November 9, 2017
Project Number 17029

Response to Public Comment and Mitigation Plan Peer Review Comments

Critical Area Determinations: CAO17-0008 & CAO17-009
8375 & 8379 E Mercer Way – Mercer Island, Washington

**1 SITE PREPARATION**

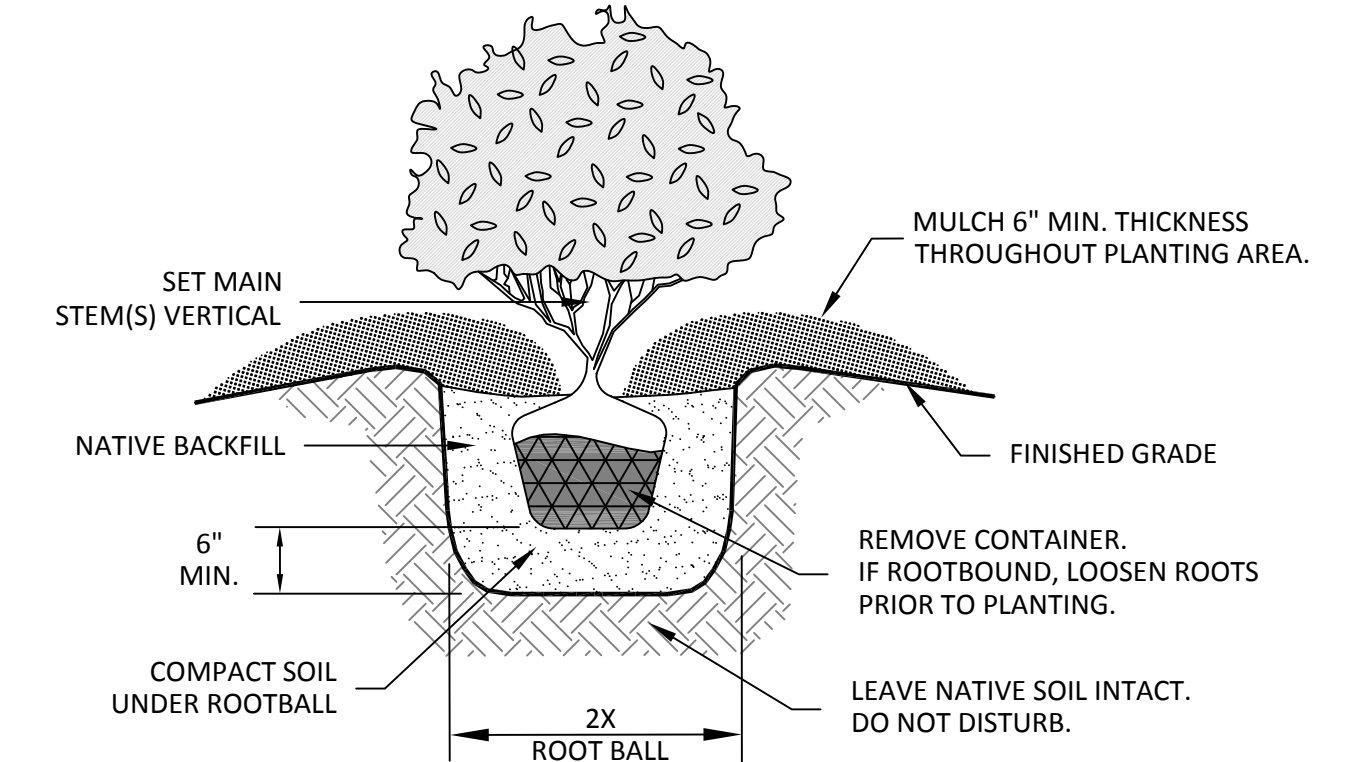
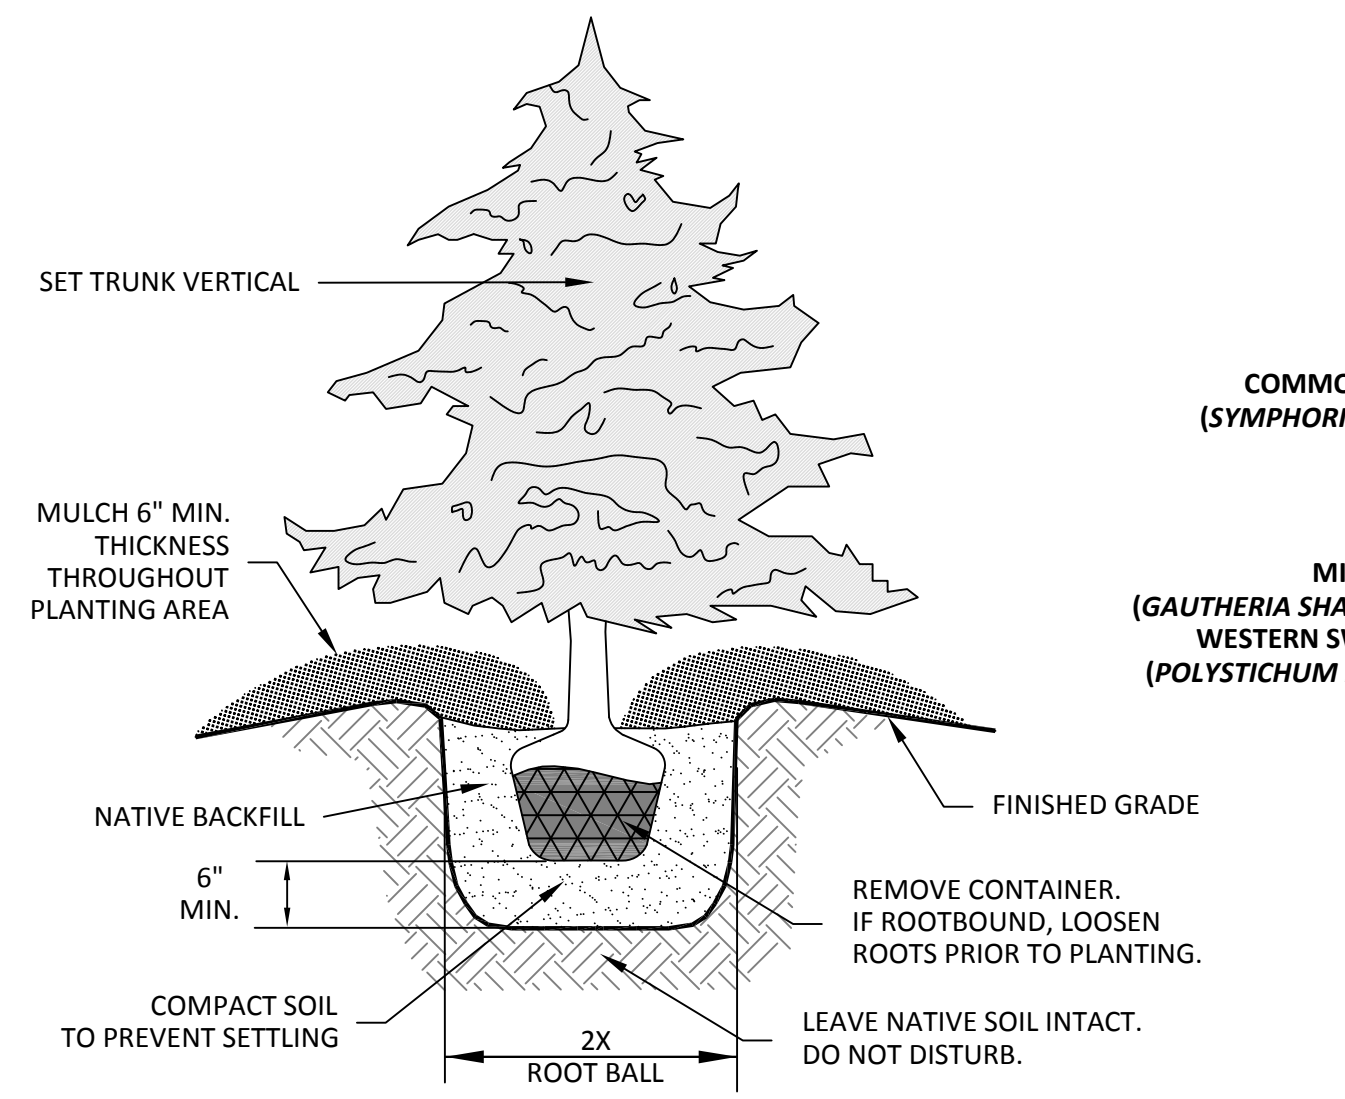
- c) Remove blackberry and other invasive species from wetland or wetland boundary

Response: The mitigation plan has been revised to require removal of all Class "A", "B", and "C" noxious weeds (including non-regulated "B" and "C" noxious weeds and "Weeds of Concern" identified on the latest King County noxious weed list from both the wetland and buffer.

**PLANTING PLAN, SPECIFICATIONS, AND DETAILS**

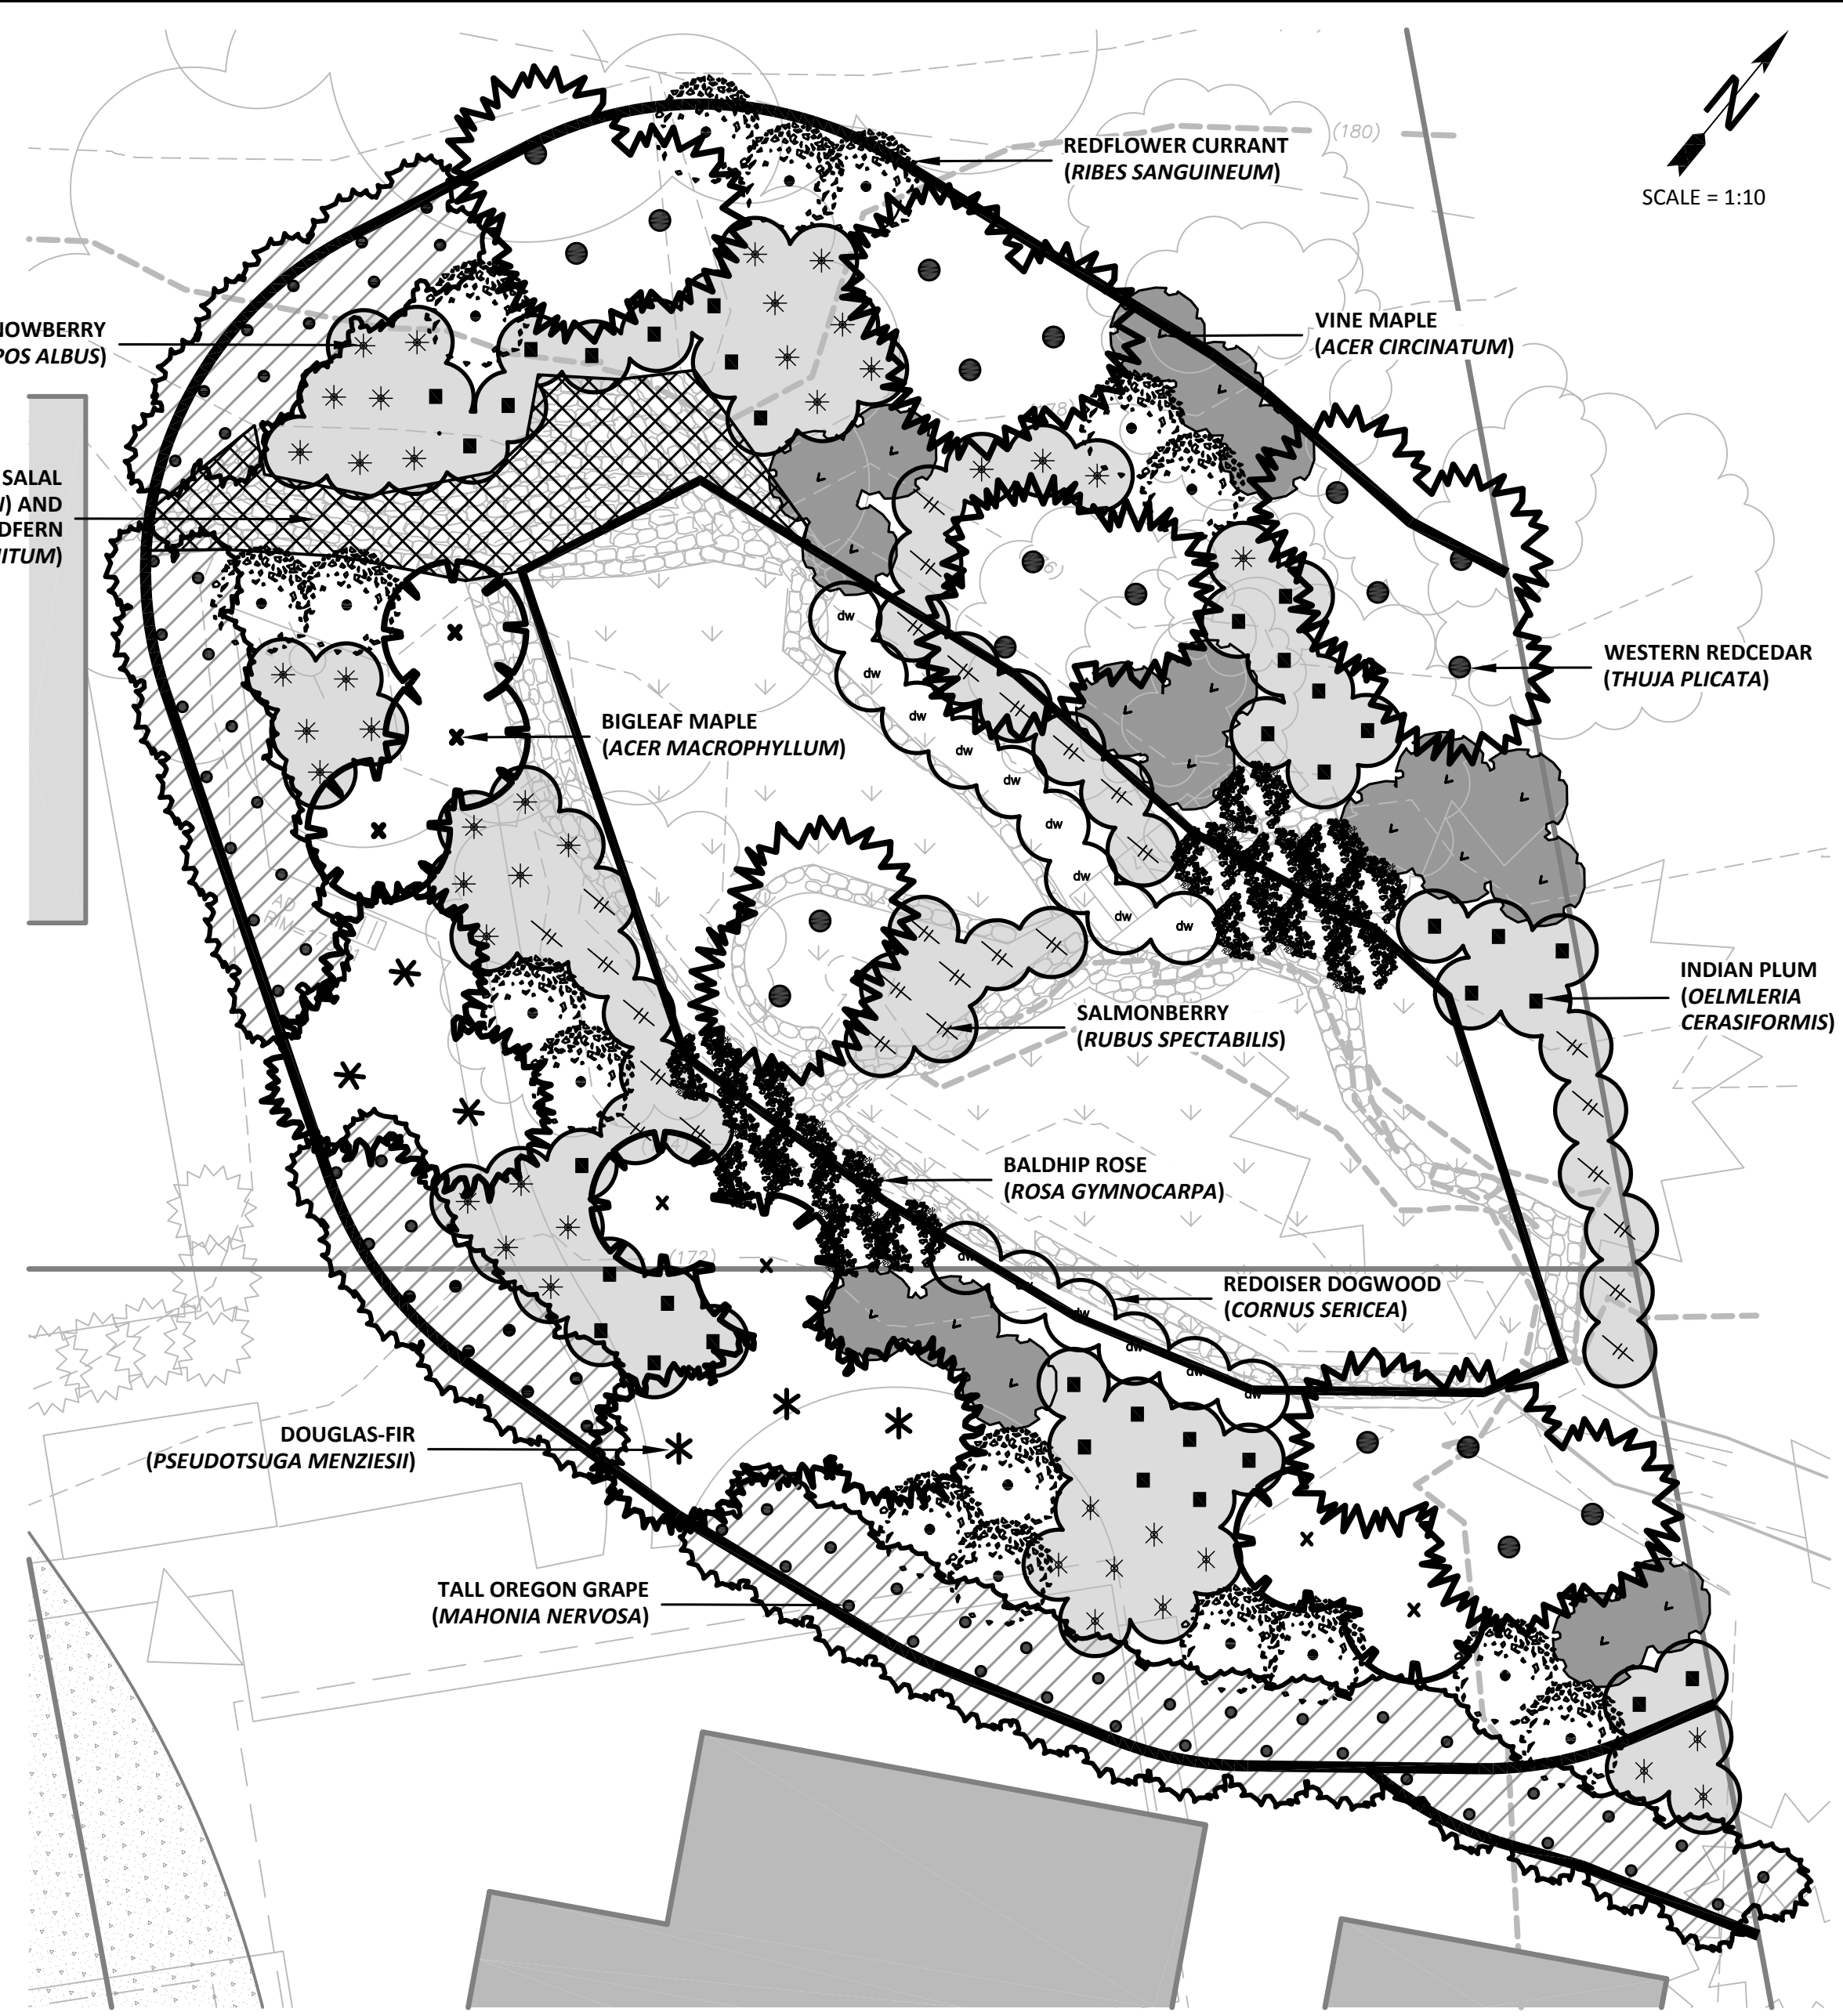
- b) Increase tree spacing to at least 8 feet apart.

Response: The planting plan has been revised to show a minimum tree spacing of 8 feet and the plant schedule has been revised to require a minimum tree spacing of 8 feet.
